Harbourside Shopping Centre

Submission to SSD 16_7874

Submitted to NSW Department of Planning & Environment
On Behalf of AAPC Limited (Novotel & Ibis Hotel)

February 2017 | P-17022

Image 100 Illustrative Eastern Elevation

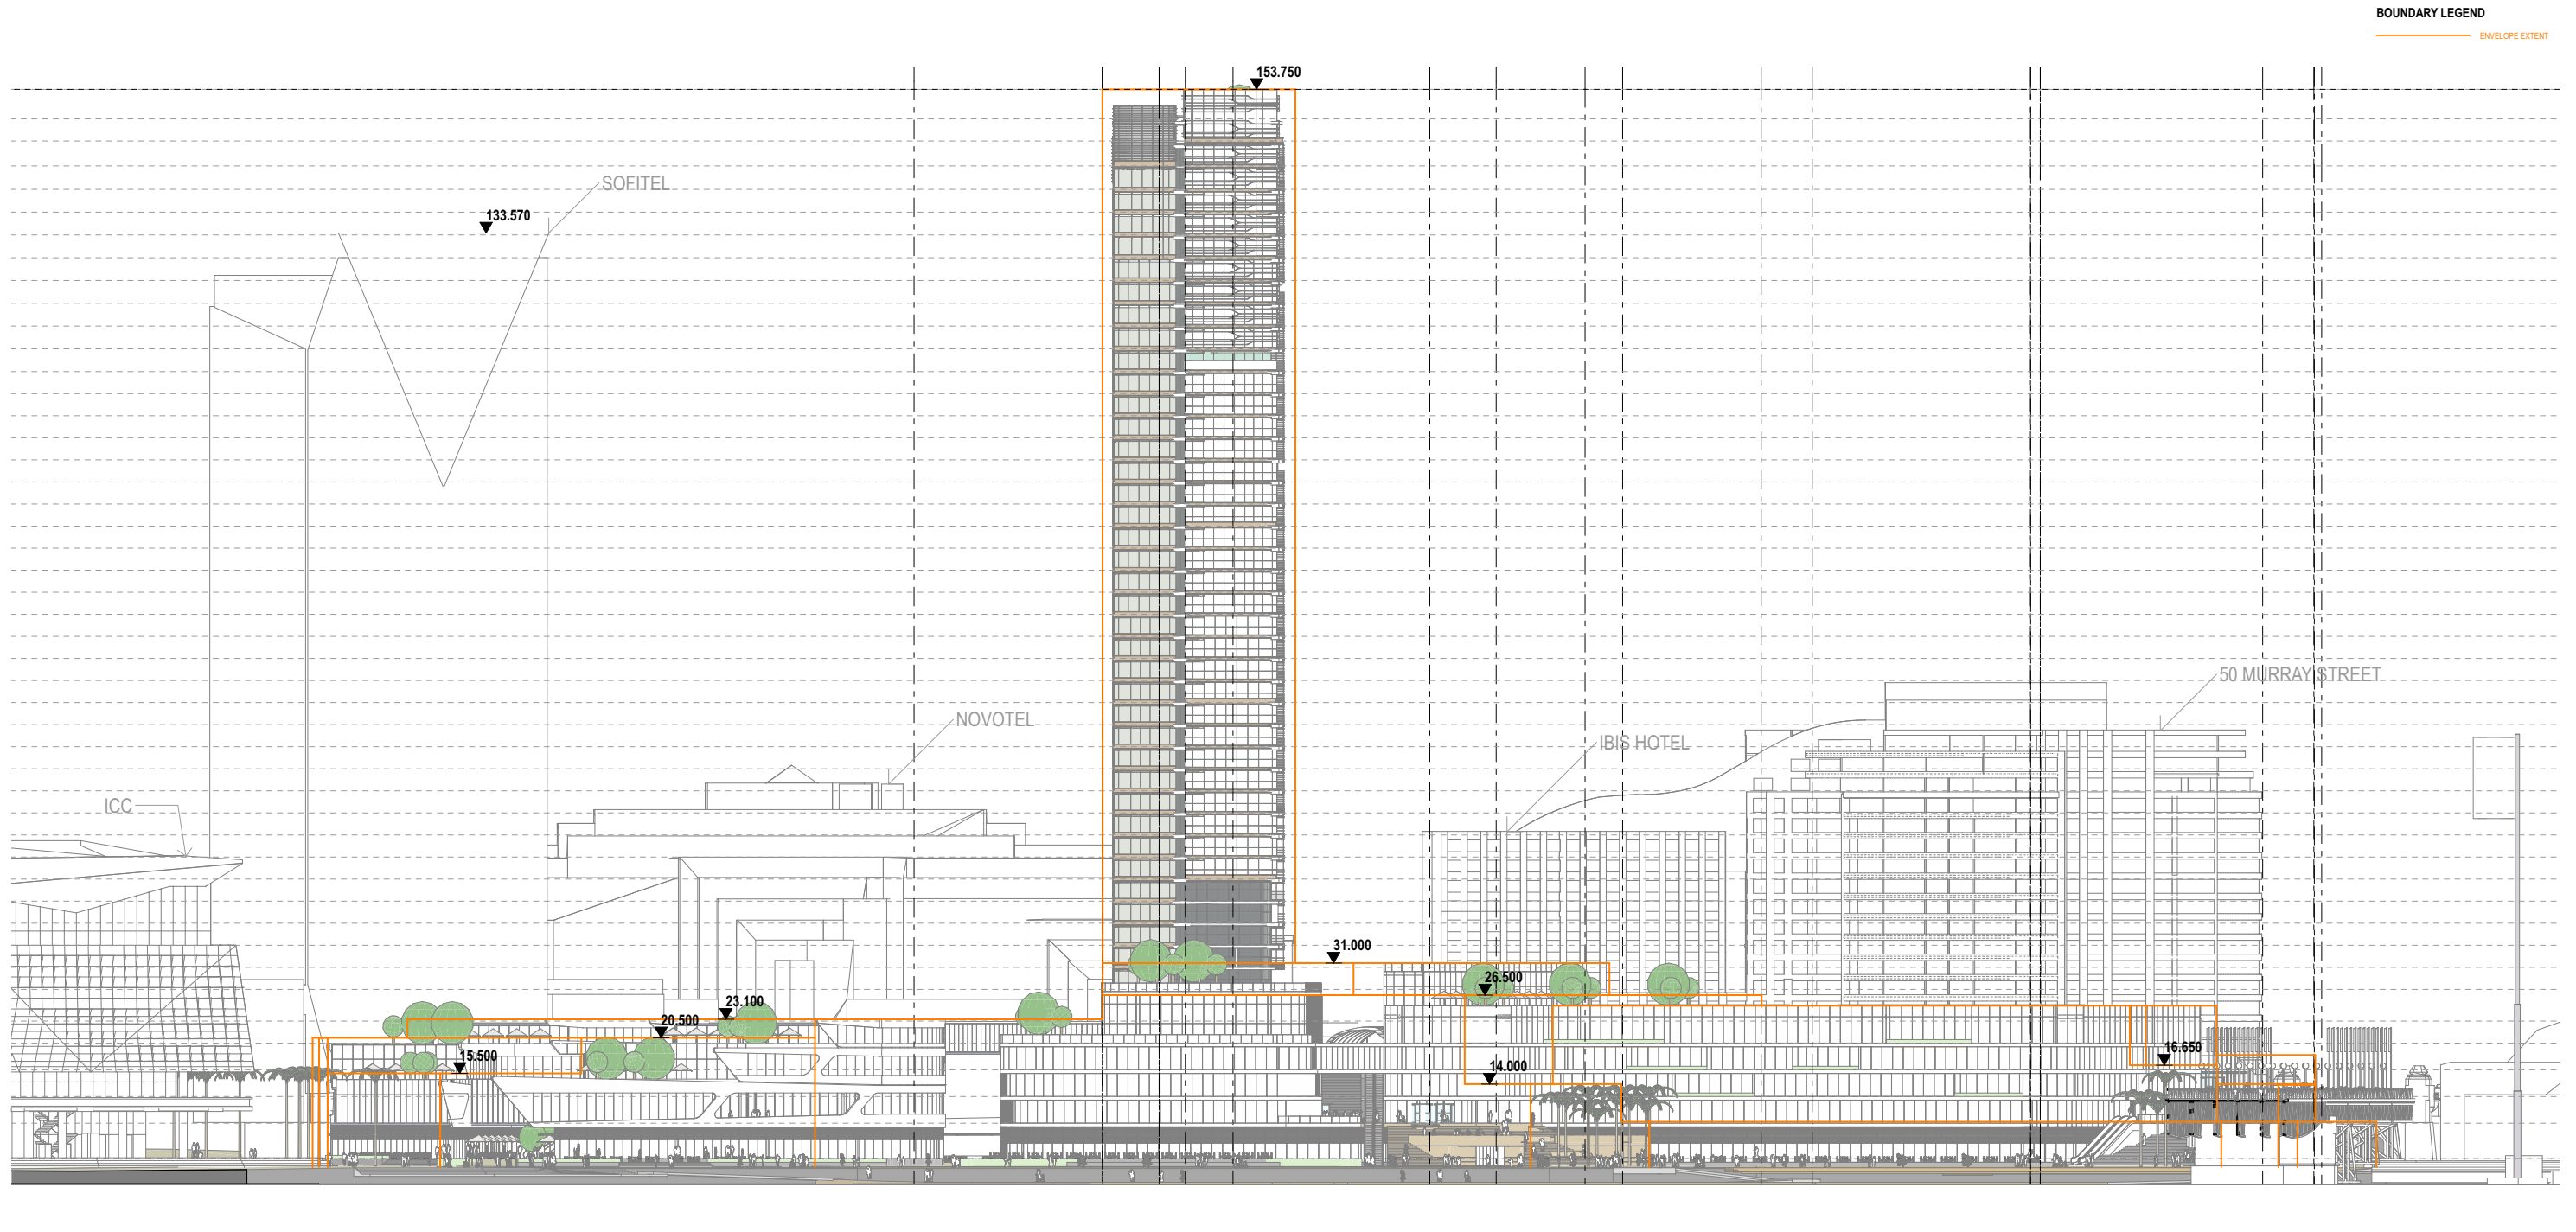
In the absence of more detailed analysis, we consider it necessary to reduce the whole height of the proposed podium by two (2) levels and reduce the extent of 'stepping' towards the lower end of the proposed tower, as indicated in **Appendix A** to this submission.

Our assessment of the proposal's view impacts is that the proposal would not satisfy the abovementioned matters for consideration. In particular, views towards Pyrmont Bridge would be severely obstructed from both the Ibis and Novotel hotels. We submit that the overall height of the podium and 'stepped' building envelope towards the bottom of the proposed tower does not adequately minimise impacts on views and vistas to public places and landmarks.

We submit that the height of the proposed podium, as well as the extent of 'stepping' towards the lower end of the proposed tower is suboptimal insofar as it impacts both hotels.
